CITY OF ALBUQUERQUE

October 14, 2020

RE: Taco Bell
8651 Golf Course Rd. NW
Grading and Drainage Plan
Engineer's Stamp Date: 09/10/20
Hydrology File: C12D058

# GRADING AND DRAINAGE PLAN

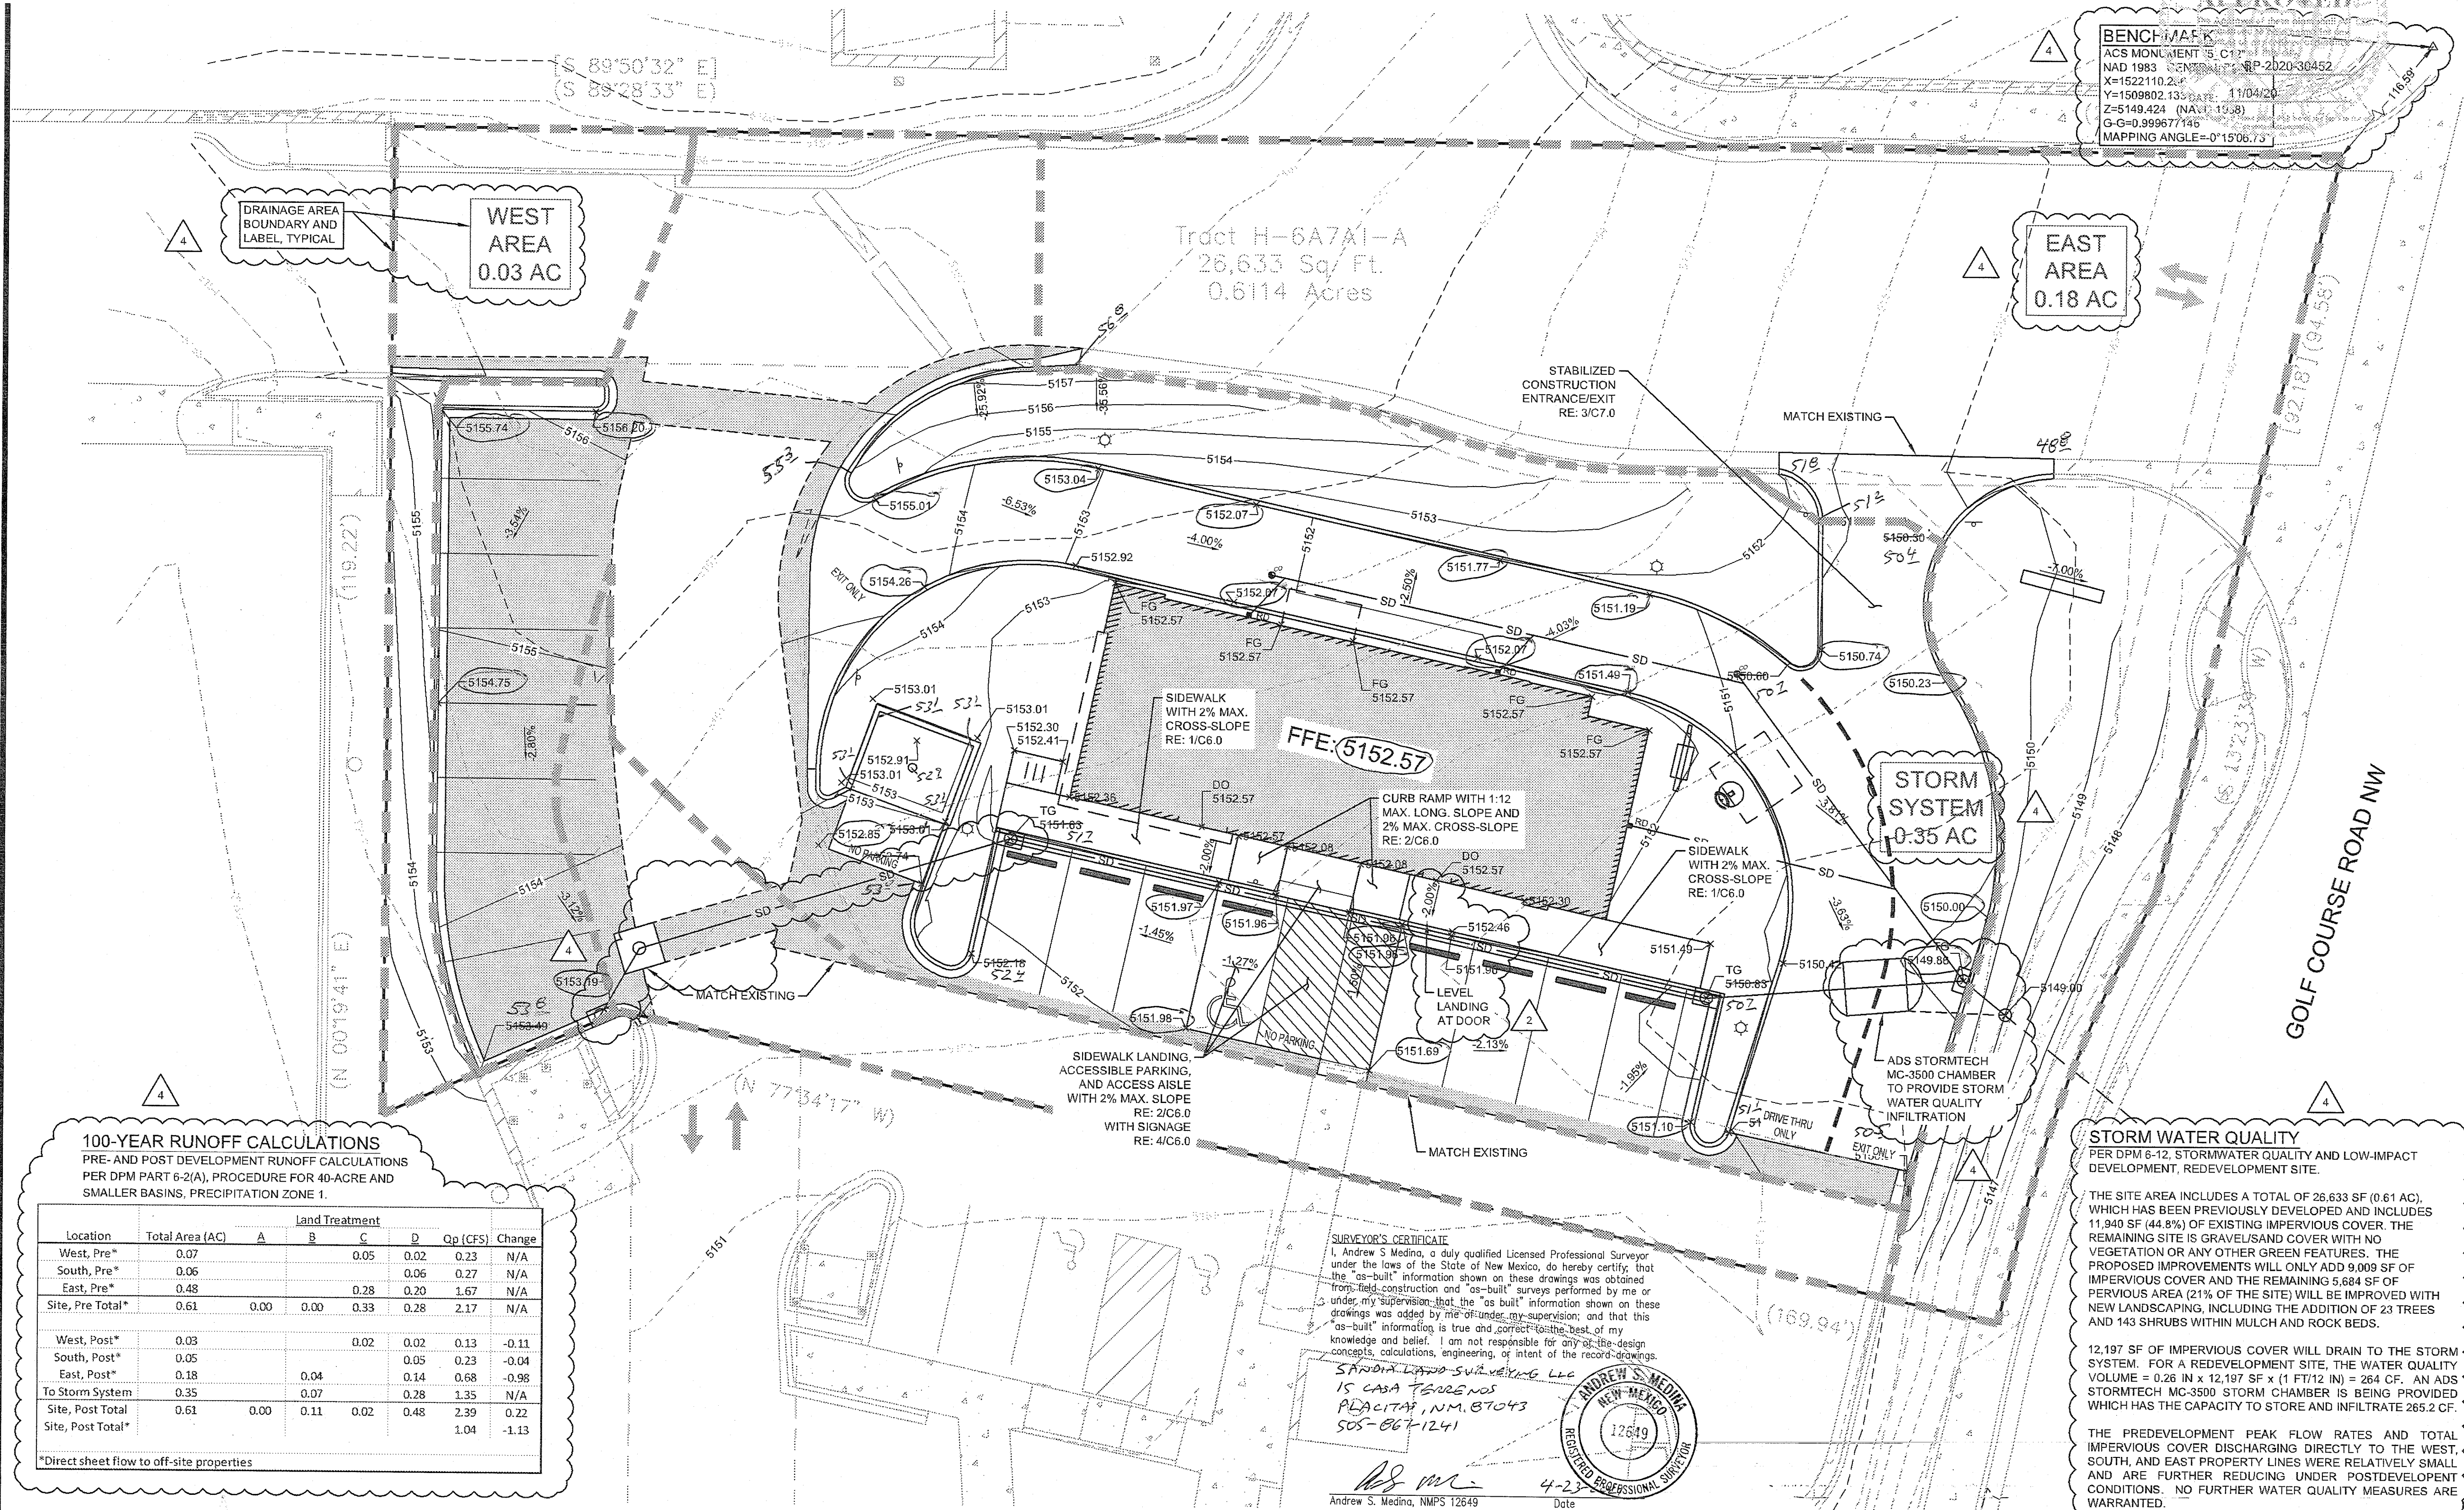
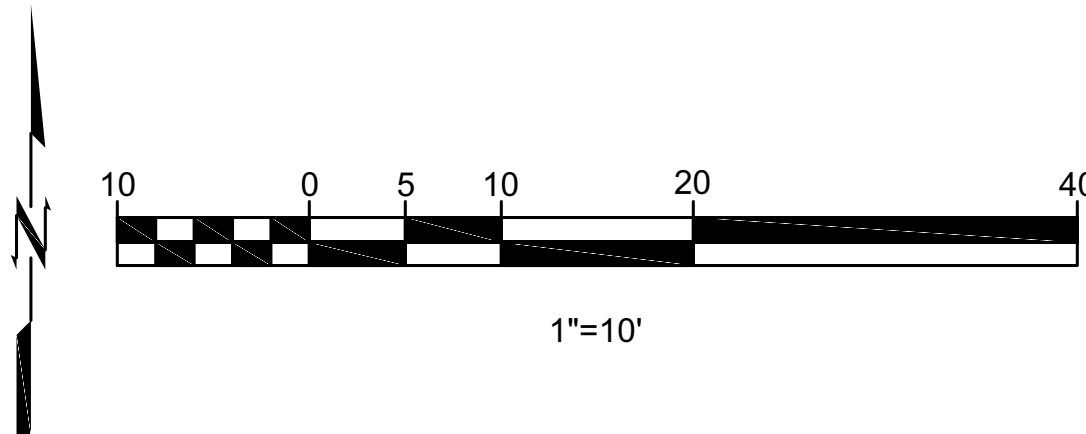
1. Please provide the Benchmark information (location, description and elevation) for the survey information provided.
2. All drainage within this site is to be captured within the property and cannot be sheet drained to adjacent property. This site was previous designed the way per a previous project (HydroTrans # C12D002F) with engineering stamp date 10/20/05.

3. Please use the procedure for 40 acre and smaller basins as outlined in Development Process Manual (DPM) (signed 06/08/20) Article 6-2(a). Please provide both the existing conditions and proposed conditions for the 100 year-6 hour storm event.

4. Provide management onsite for the Stormwater Quality Volume (SWQV) in accordance with the new drainage ordinance, § 14-5-2-6 (H) enacted 10/2/18 (Council Bill C/S O-18-2). Please show the top and bottom of the ponds along with the volume for each pond. The onsite drainage should be directed to these ponds prior to being collected in a private unground drainage system. Please follow the DPM (signed 06/08/20) Article 6-12 Stormwater Quality and Low-Impact Development for the sizing calculations.
